From: Laura Gibbons
Sent: 05 September 2019 10:37
To: Planning.Responses <Planning.Responses@arun.gov.uk>
Cc: Andrew Wood <Andrew.Wood@arun.gov.uk>
Subject: RE: Planning Consultation on A/113/19/DOC

Engineers Comments Regarding Condition 9- surface water drainage design

APPLICATION NO: A/113/19/DOC

Site Address: Crete Nursery Dappers Lane Angmering BN16 4EN

NOTES

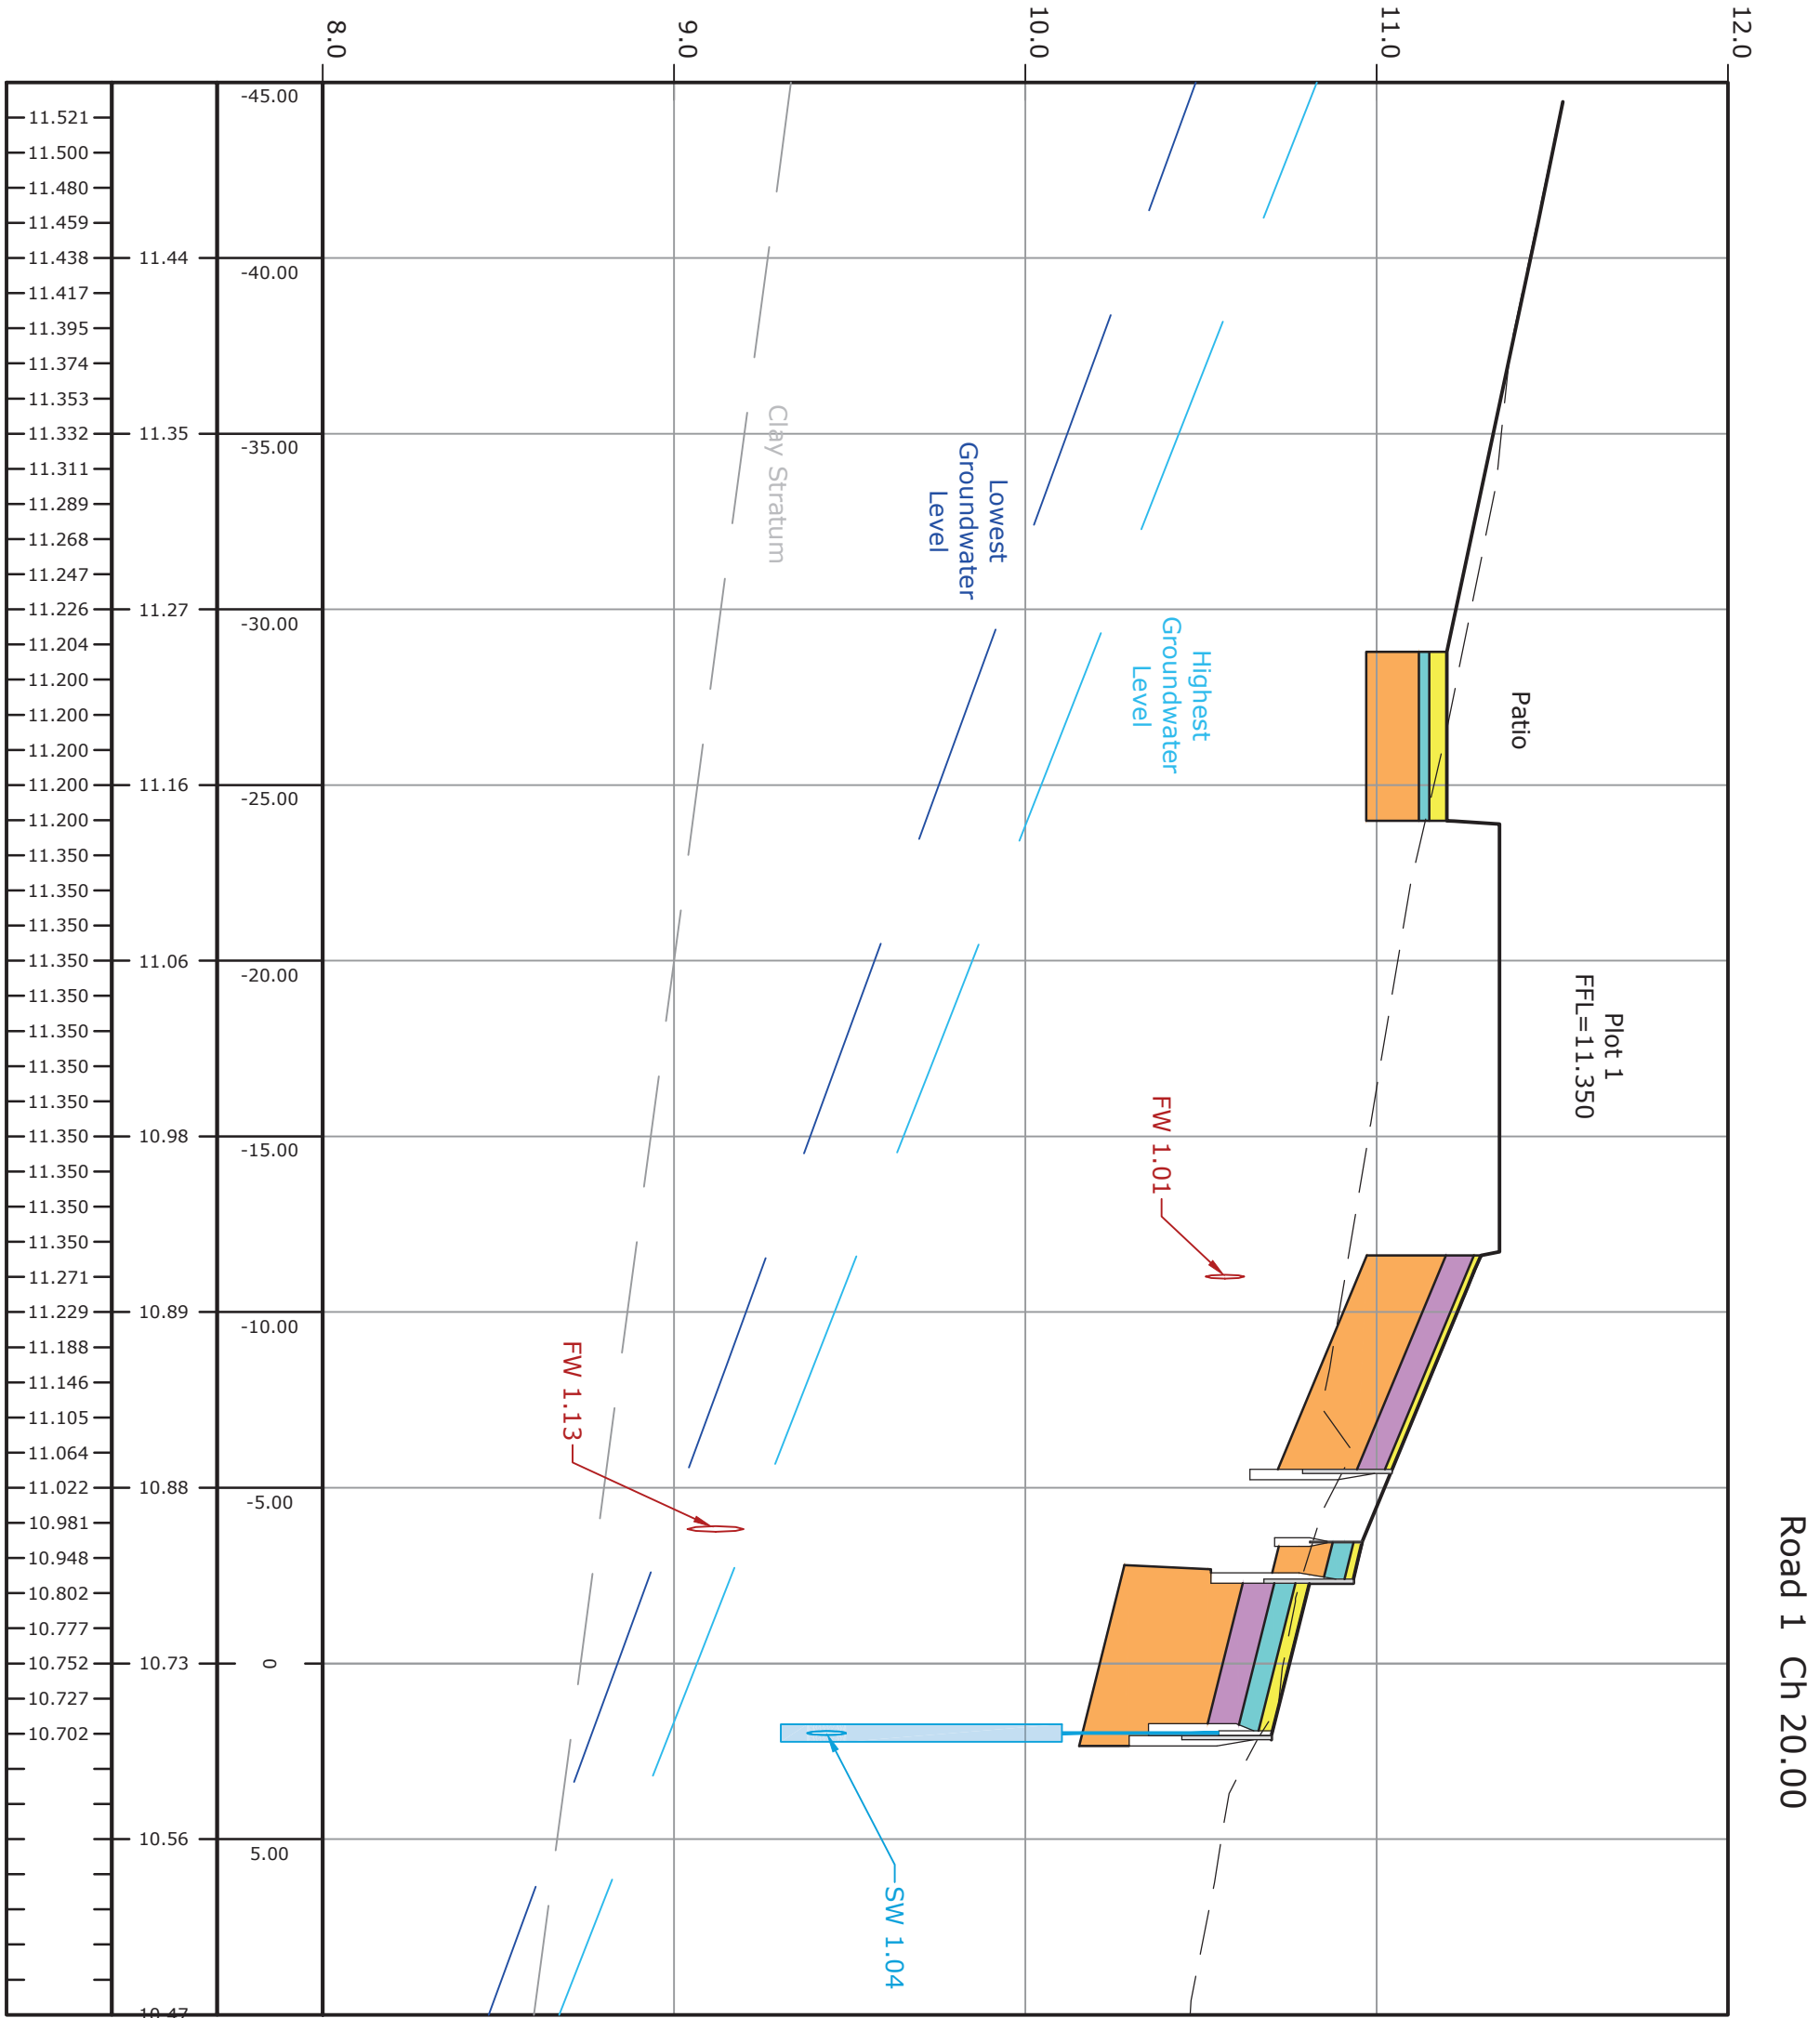
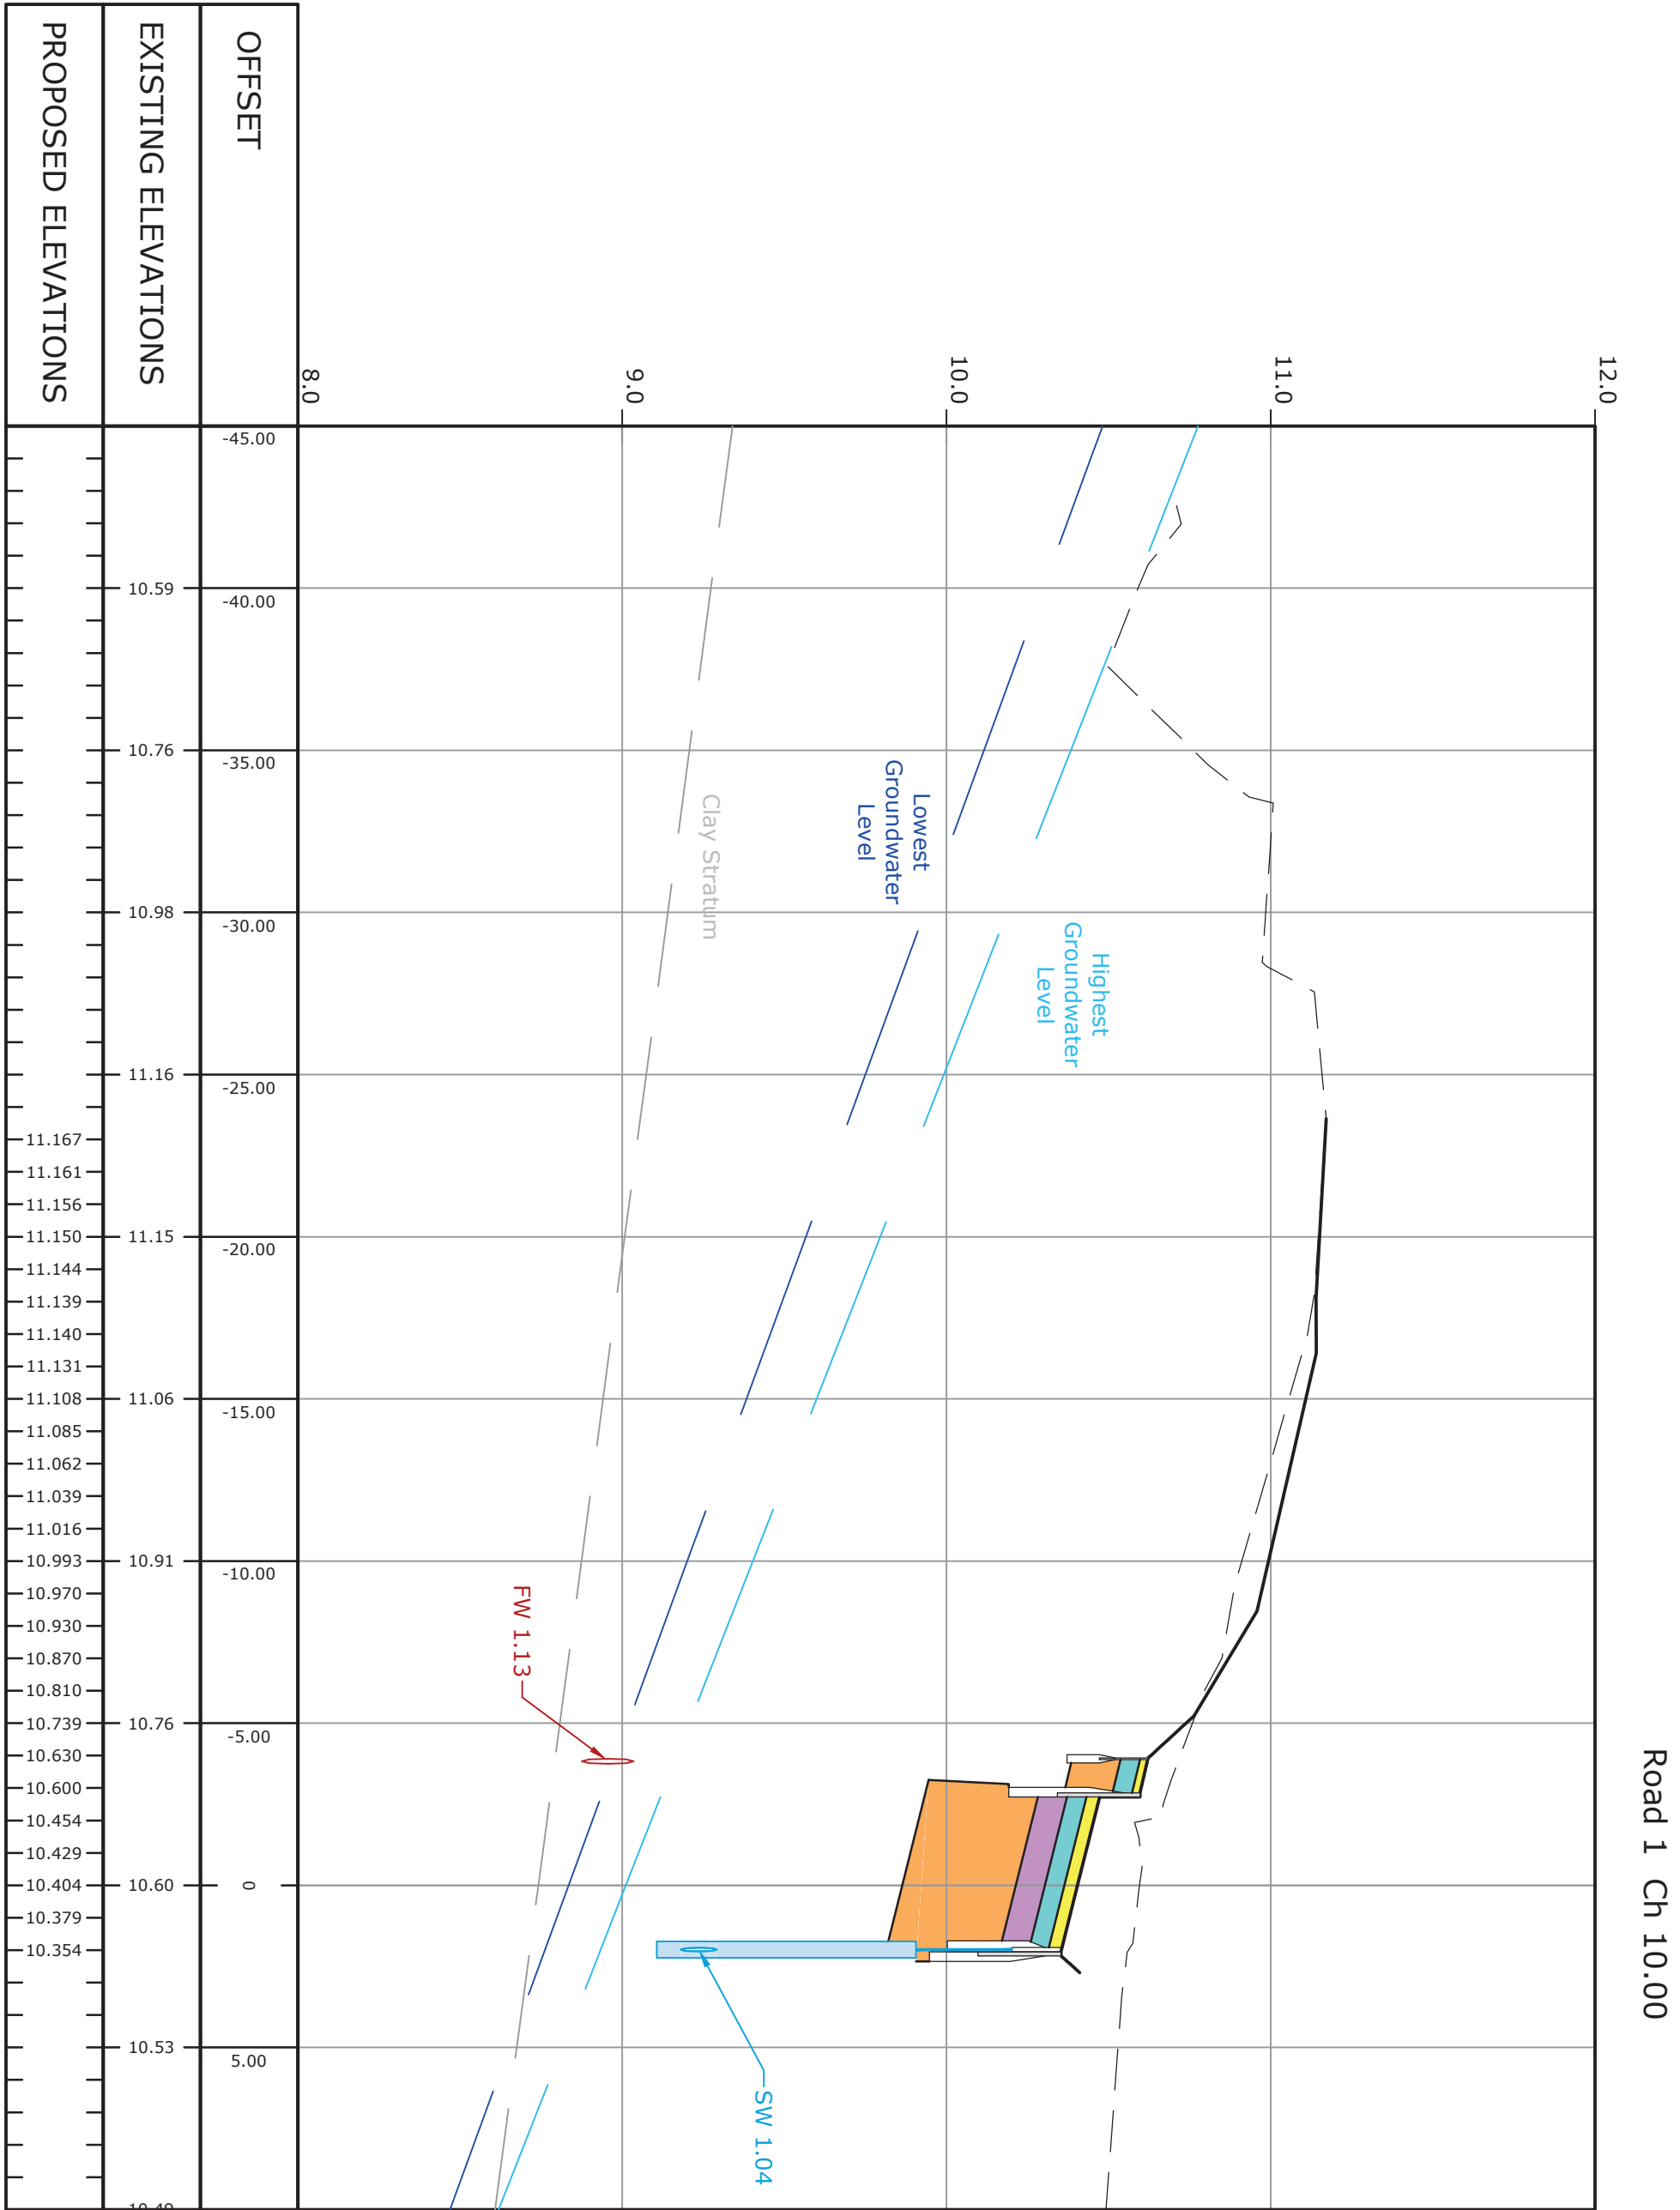
5. From looking at cross sections it also appears that the filter drain will be on a slope, please ensure this is accurately depicted within calculations.

- Notes**
- All dimensions are in meters unless expressed otherwise and all levels are shown in meters above Ordnance Datum.
 - This drawing shall be read in conjunction with the drainage schedules and standard details.

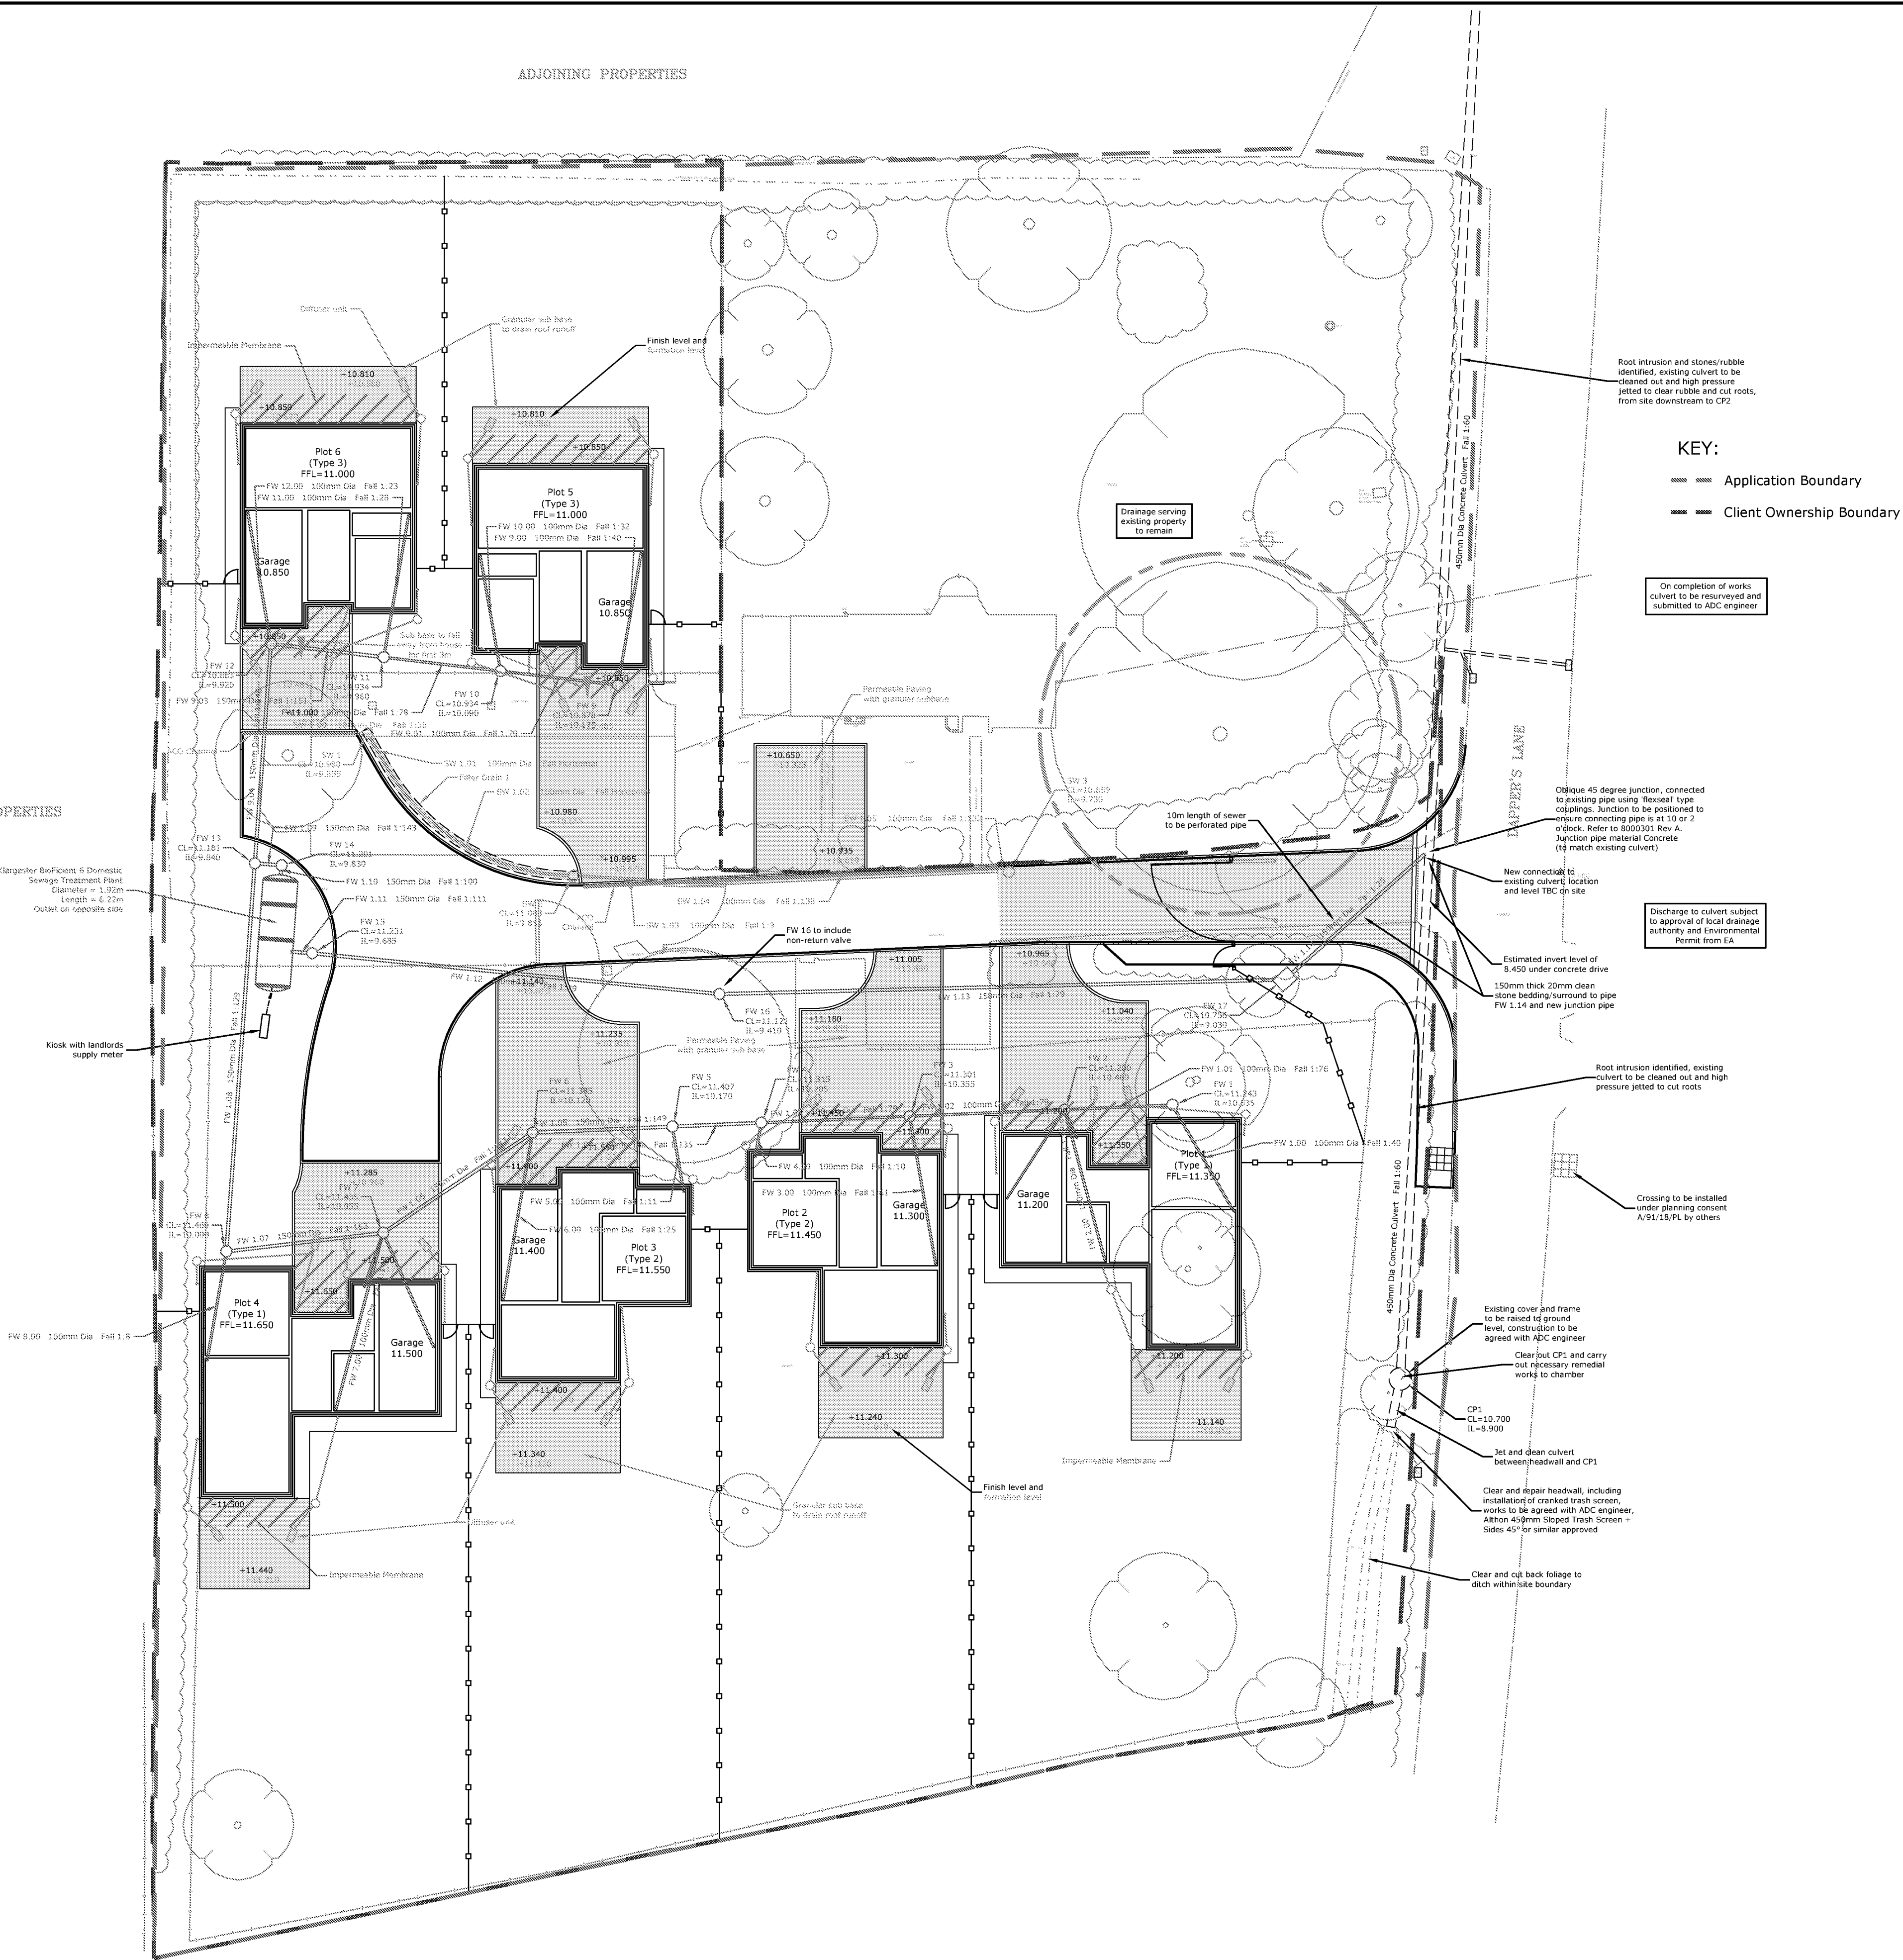
3. Please can an impermeable areas plan be provided that clearly shows the impermeable areas draining to each surface water drainage feature.
4. The filter drain is inadequate. Maximum modelled water depths are nearly 1m. This clearly will not be able to be contained above maximum recorded groundwater level.

10. Catchpits must be provided upstream of all connections to permeable paving. Please ensure the location of rwp, catchpits, and connections to permeable areas are clearly shown on plan.
11. Please provide invert levels and cover levels of all inspection chambers, manholes, filter drains, etc. Please also ensure that finish and formation level of permeable paving is clearly provided on plan.
